**Planning and Development Department**  
Lee D. Urban, Director

July 1, 2005

RE: Proposed Amendment to an Approved Site Plan  
Inn on Peaks – 33 Island Avenue – Walkway and Ground Leveling  
Application #2005-0134

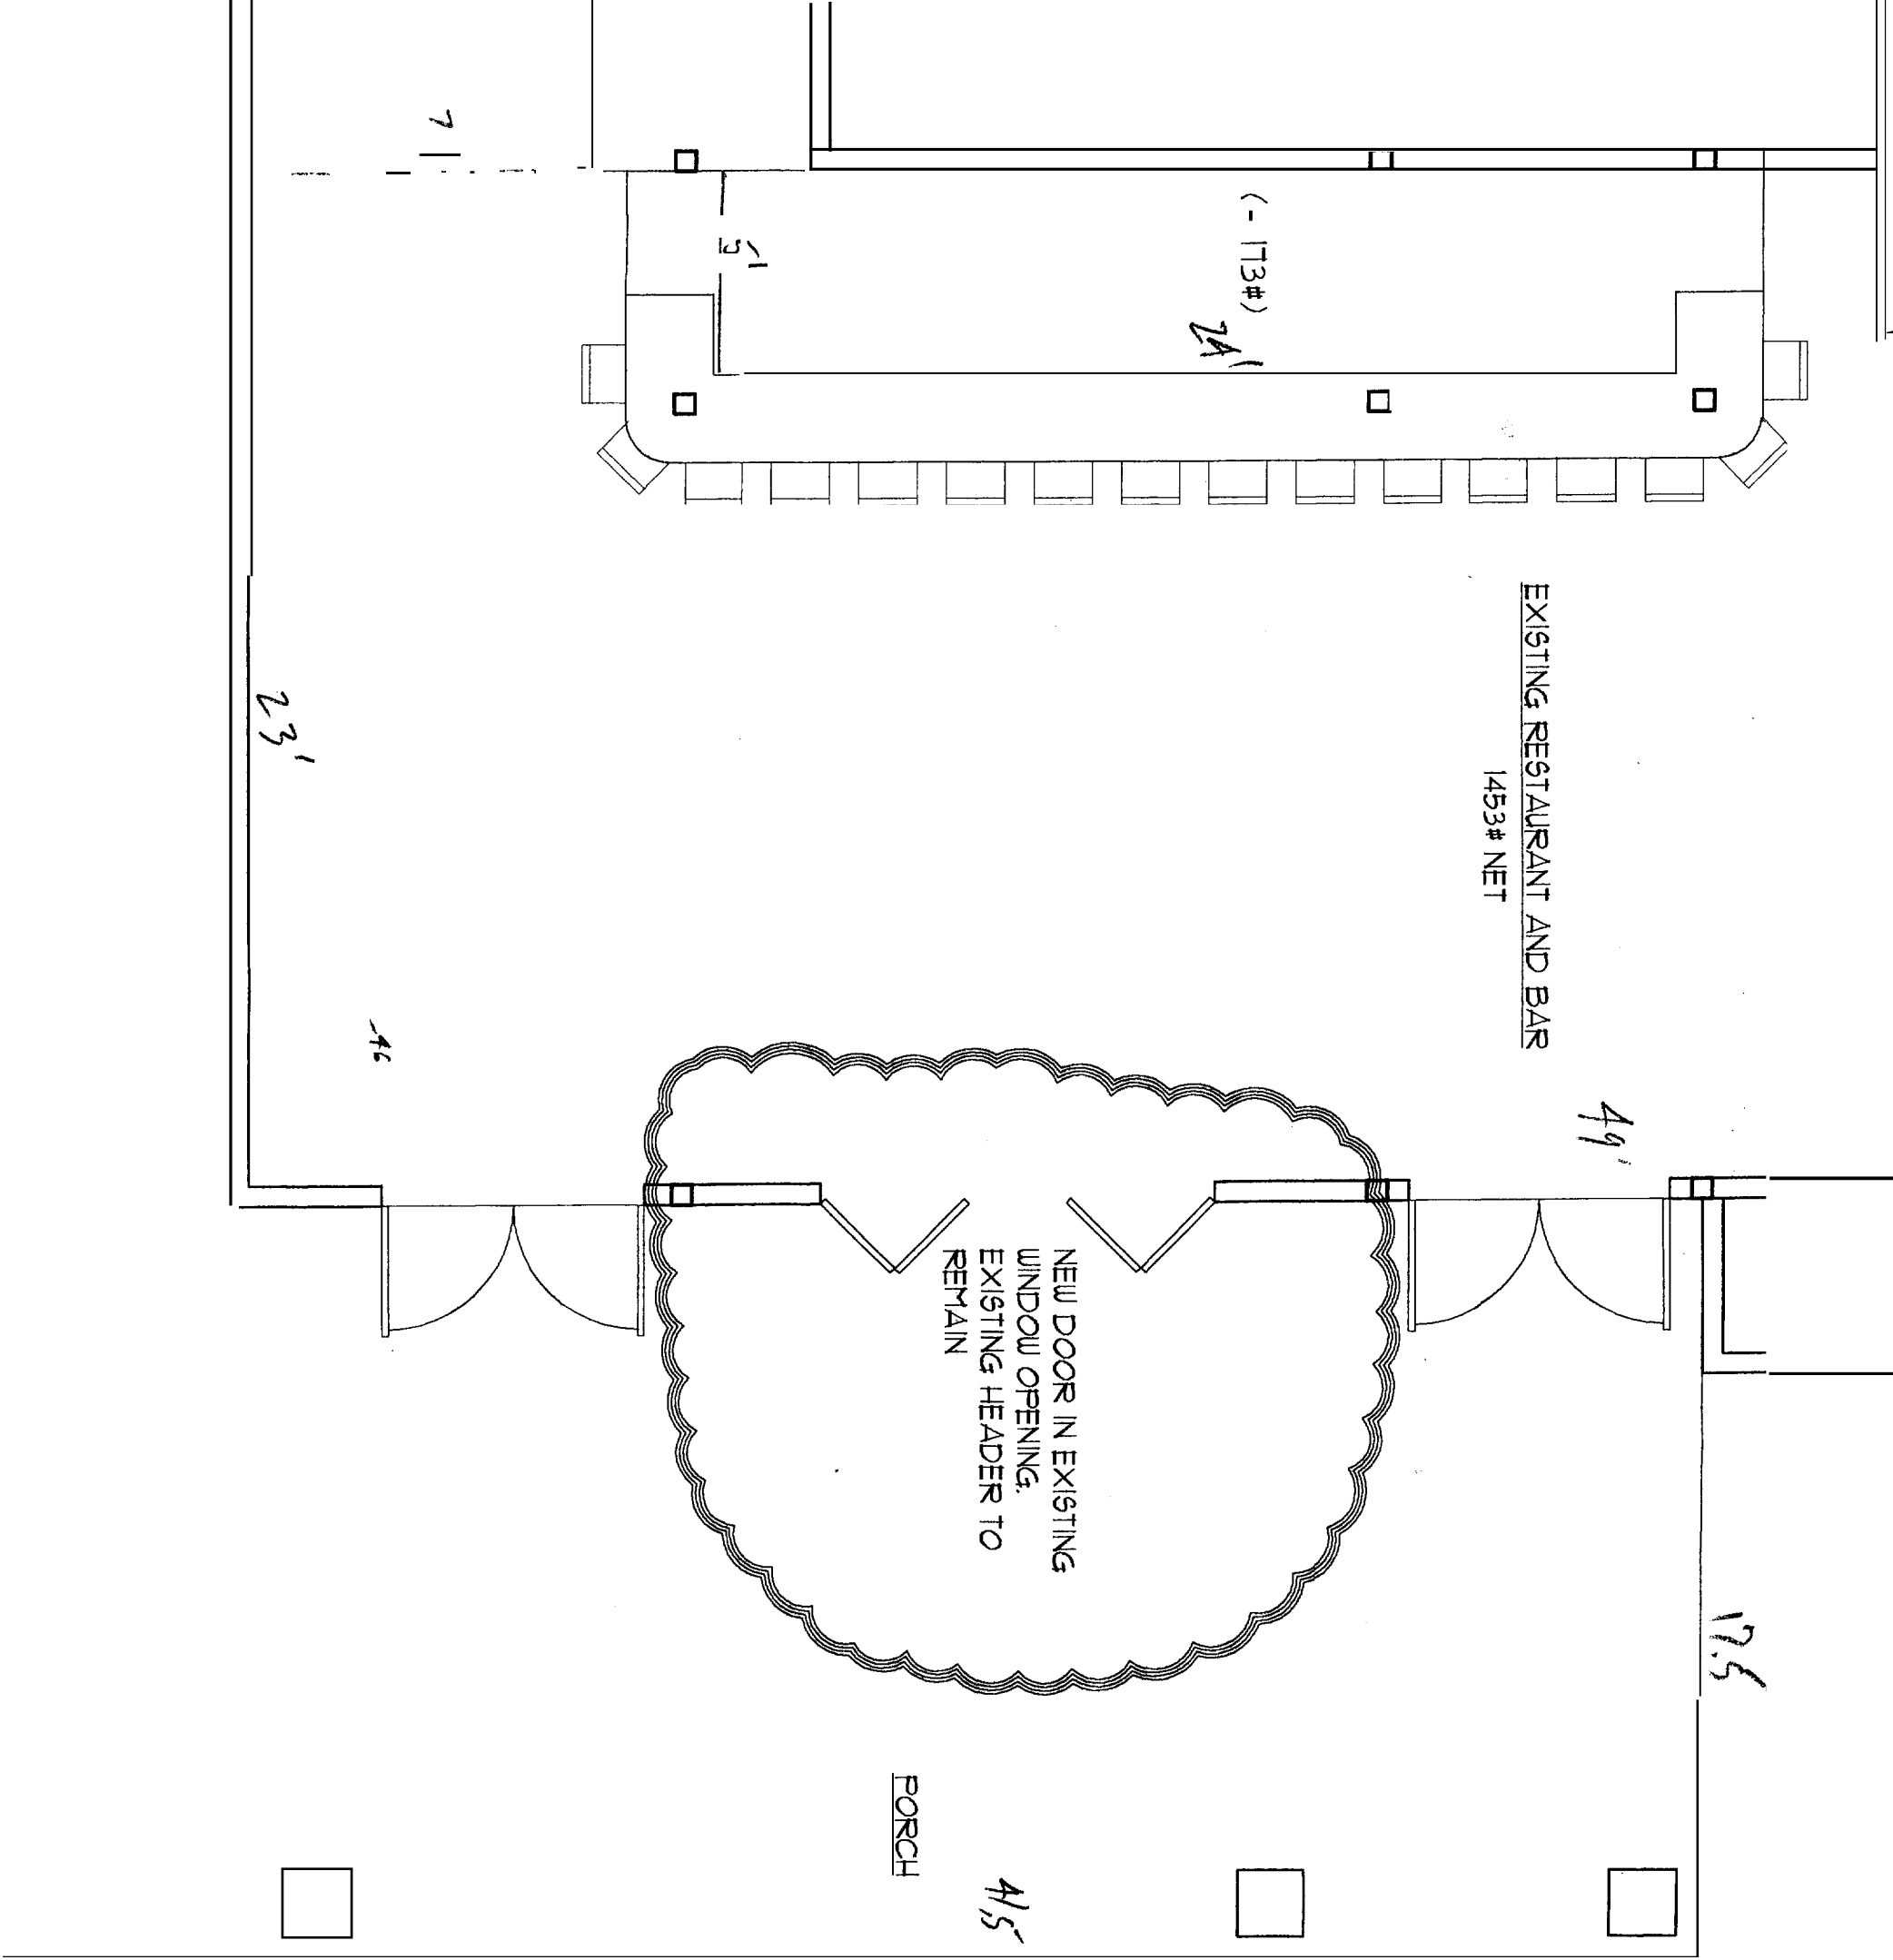
- A. The application submitted May 13, 2005 is for "Walkway and Ground Leveling", however the site plan submitted June 2, 2005 shows no changes to grades and no proposed walkway is identified.

- B. The application form and site plan make no reference to the 3,200 square foot tent, which is detailed in your June 21, 2005 memo. Please provide elevations and specifications of the proposed tent as may be found in vendor's catalog cuts. Please also indicate on the site plan where the tent is proposed to be sited.

- A. The surface conditions under the proposed canopy are brick, but the plans call for stone dust. Will the surface be regarded and reworked under the canopy? Appropriate BMPs will need to be shown installed on the plan. Also the applicant shall be responsible for sweeping and clearing the parking area and all access from tracked soils, and or dust from tracked materials.

- B. Drainage from the canopy will drain under and through the covered area as shown. Please provide means of directing drainage towards the existing catch basin in Island Ave. We recommend a French Drain type of installation along the drip edge and tying it to the street drainage. Due to seasonal use freezing will not be a problem or concern.
- C. The gravel surface between proposed gravel pads on the northeast corner of the building will be problematic unless a drain is installed or unless the entire driveway is capped in concrete or bituminous. Runoff will saturate the gravel and the difference in materials will create ruts along the edges and will further pond water and deteriorate both concrete and gravel surfaces. If the area was paved or installed with concrete both the maintenance conditions and life expectancy will be enhanced.

- D. The site plan given to determine zoning is inaccurate. The tent hangs over an existing porch in order to meet the setback requirements (ten feet to the side property line). In real space on the face of the earth, that can only mean that the 40' x 80' tent cannot meet the setbacks when placed on site. Perhaps a narrower tent should be considered.
